# Highways Response Note

- 1.1 This note has been prepared in response to the Highways comments made by the Greater London Authority (GLA) in a letter dated 23<sup>rd</sup> January 2023 regarding planning application (28301/APP/2022/2205) for the redevelopment of the site known as Harefield Grove located in Harefield in the London Borough of Hillingdon.
- 1.2 The highways comments made by GLA are set out in turn below along with our response to each comment made.

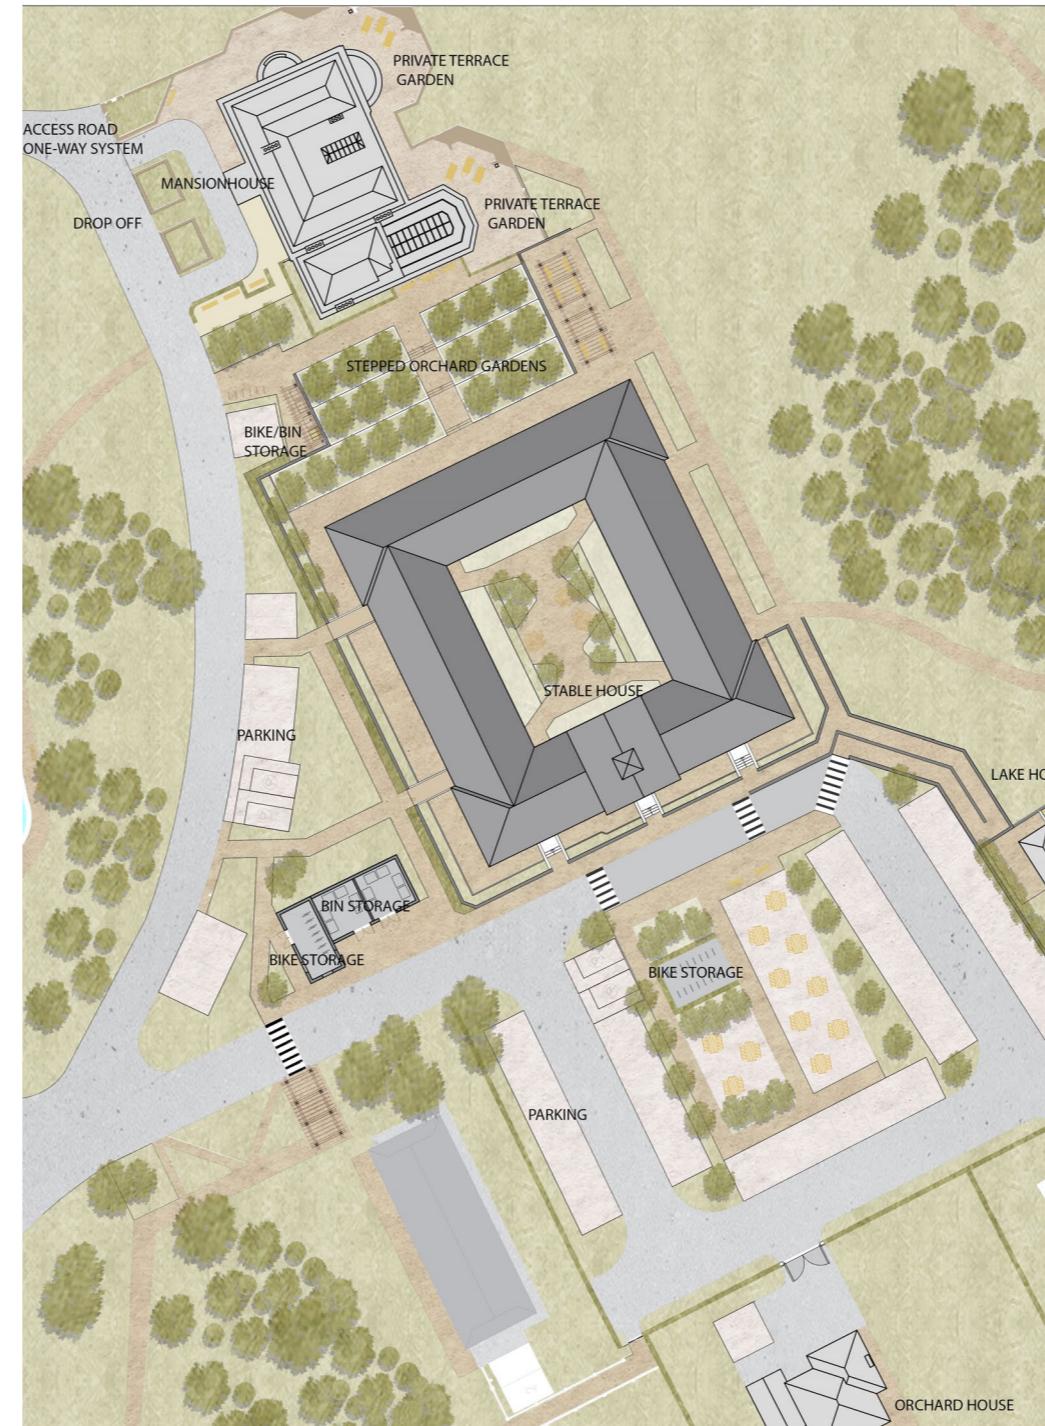
*“115 - There is a concern that areas of the site appear to be car-dominated, which is contrary to Policy T2 of the London Plan. Furthermore, there does not appear to be any clear and safe spaces for pedestrians from some of the cycle parking provision and parking provision located within the parking area to the main residential entrances. A reduction in the quantum of parking could assist in addressing this.”*

1.15 To maximise pedestrian permeability it is intended that the internal access arrangements will operate predominately on a shared space arrangement, with off-road walking routes also provided throughout the site.

1.16 The nature of the proposed development very much lends itself for the internal access arrangements to operate on a shared space basis for the following reasons:

- low traffic numbers – as set out in the Transport Statement submitted with the application, the proposals will only generate c.20 vehicle movements per hour during peak times, equating to an arrival or departure movement just once every three minutes
- low speeds - speed limit signs (10 or 15mph) will be posted along the internal access routes – details to be agreed at the detailed design stage
- traffic calming measures will be implemented along the internal access routes (i.e humps, planters etc.) to keep vehicle speeds to a minimum – details to be agreed at the detailed design stage
- appropriate shared spaced surfacing will be provided along the internal access routes, expected to be constructed from gravel surfaces to emphasise their difference from conventional streets – details to be agreed at the detailed design stage
